Application no: H18-0571-15

Description: Proposed new dwelling

Location: 62 NEW ROAD
SUTTON BRIDGE
SPALDING
PE12 9RQ

PLANNING AMENDMENT

773-02 b.

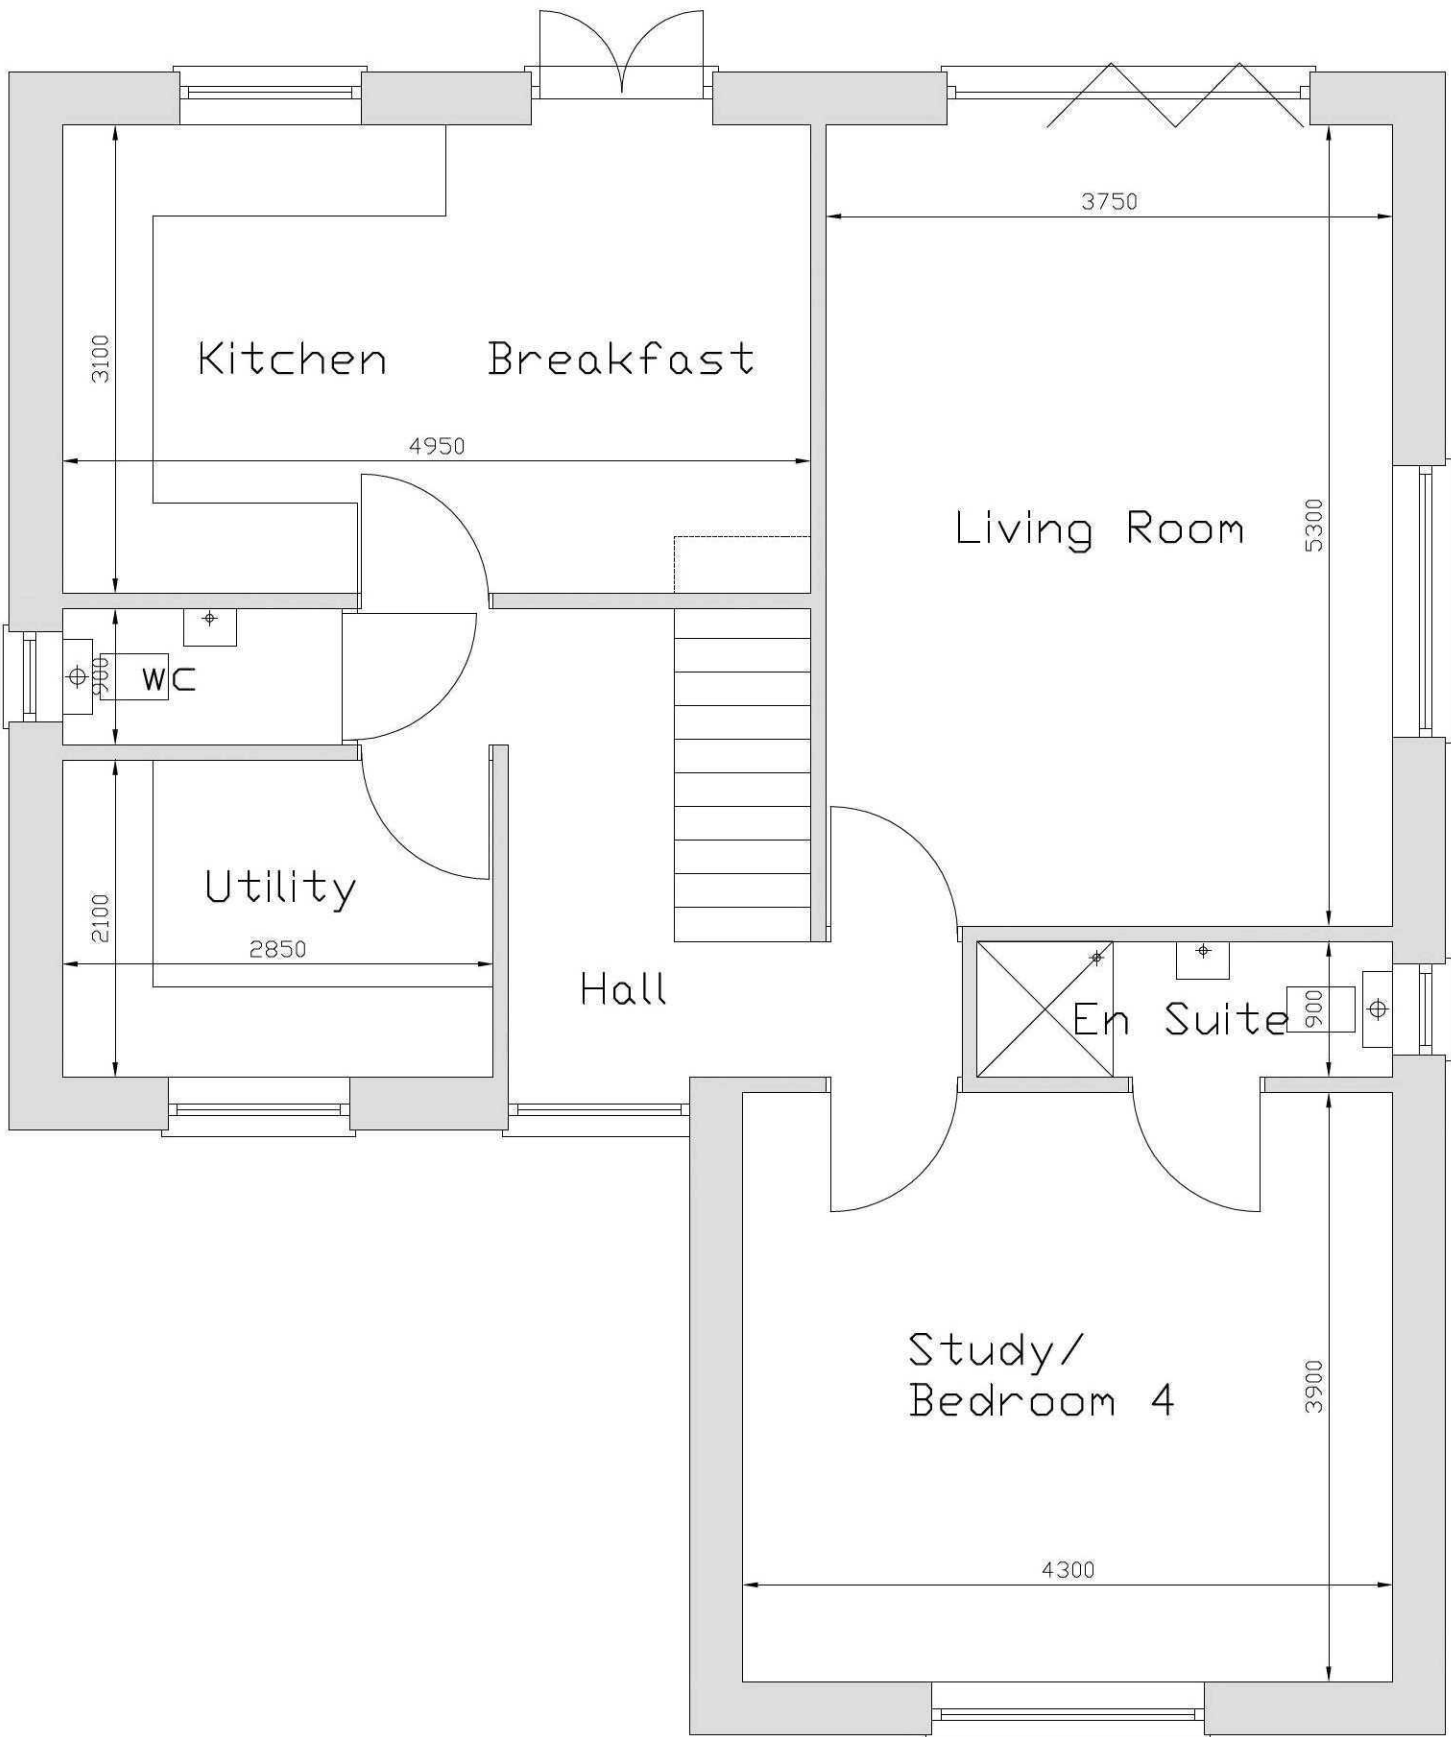
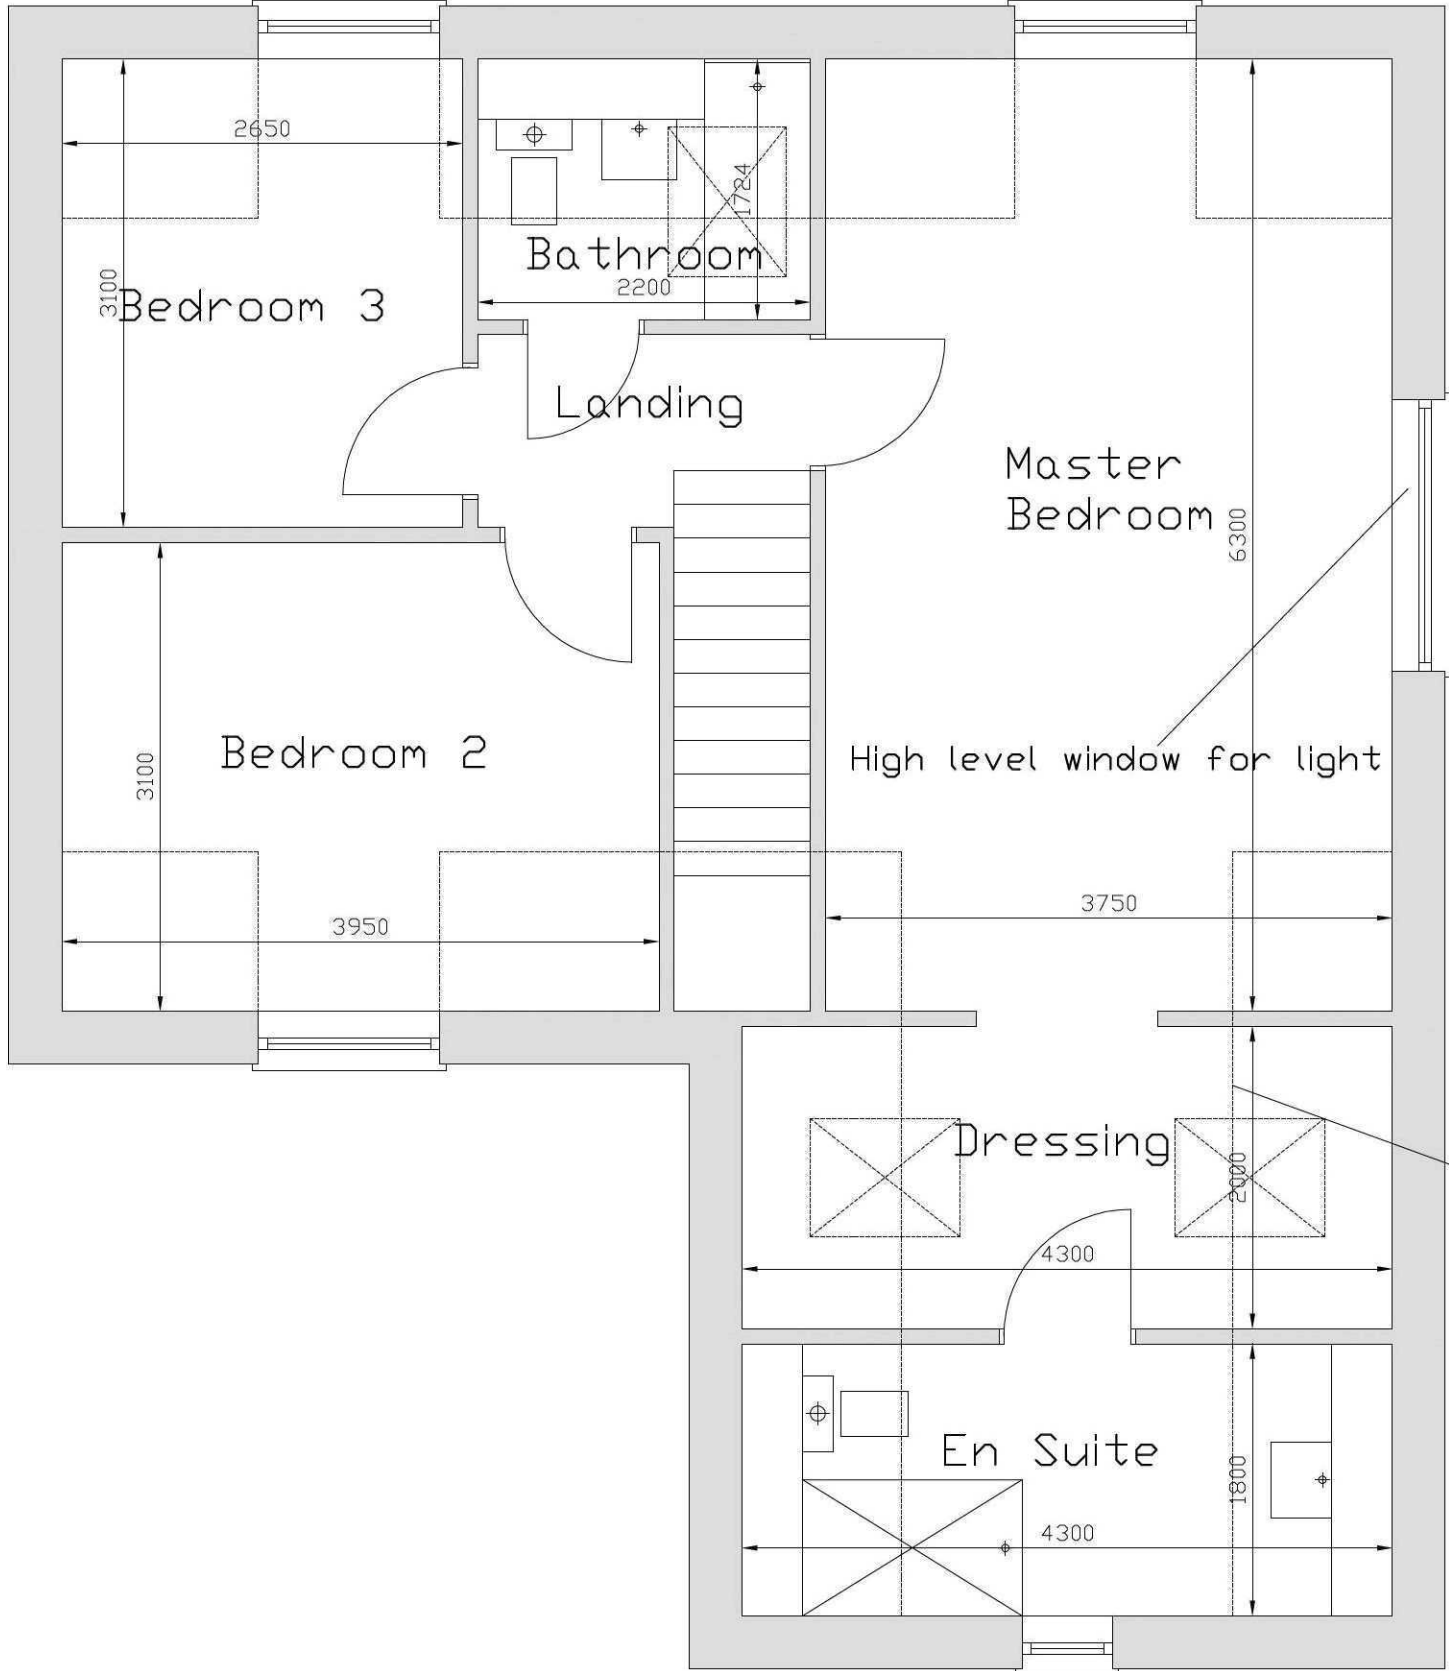
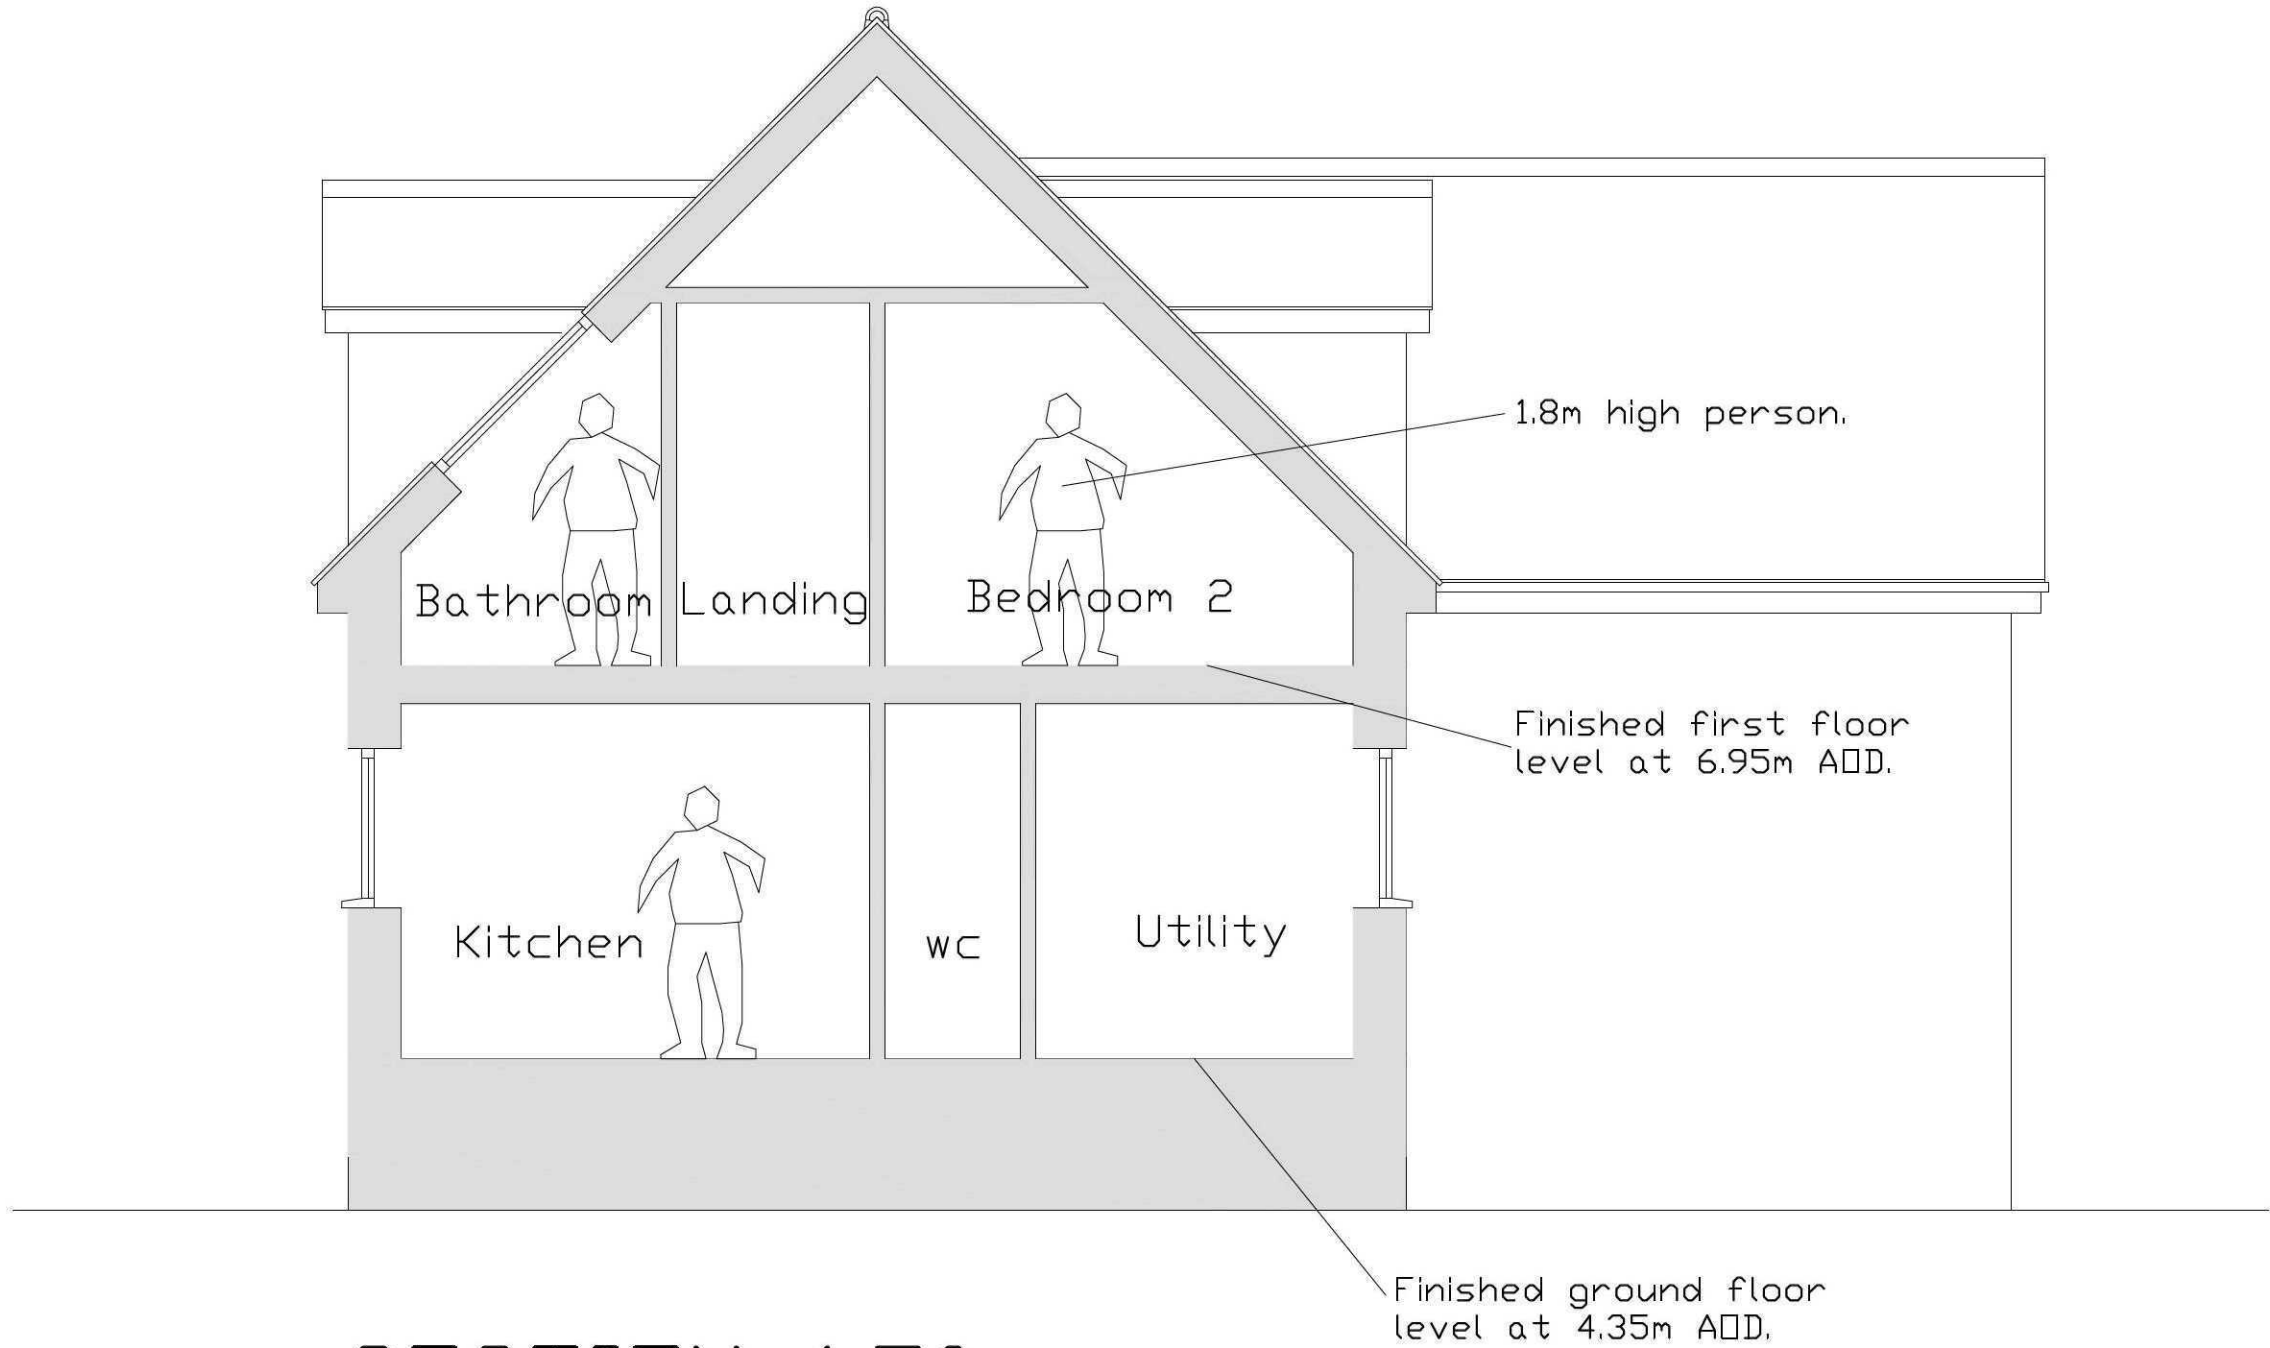
Amendment: Floor levels/buildings raised to suit Environment Agency requirements (dwgs 773-01d, 773-02b & Flood Risk Ass)

I refer to your recent e-mail and attach a completed amendment form together with the revised FRA for this project and amended drawings 773-01d & 02b that now show the ground floor level raised in accordance with EA's requirements.
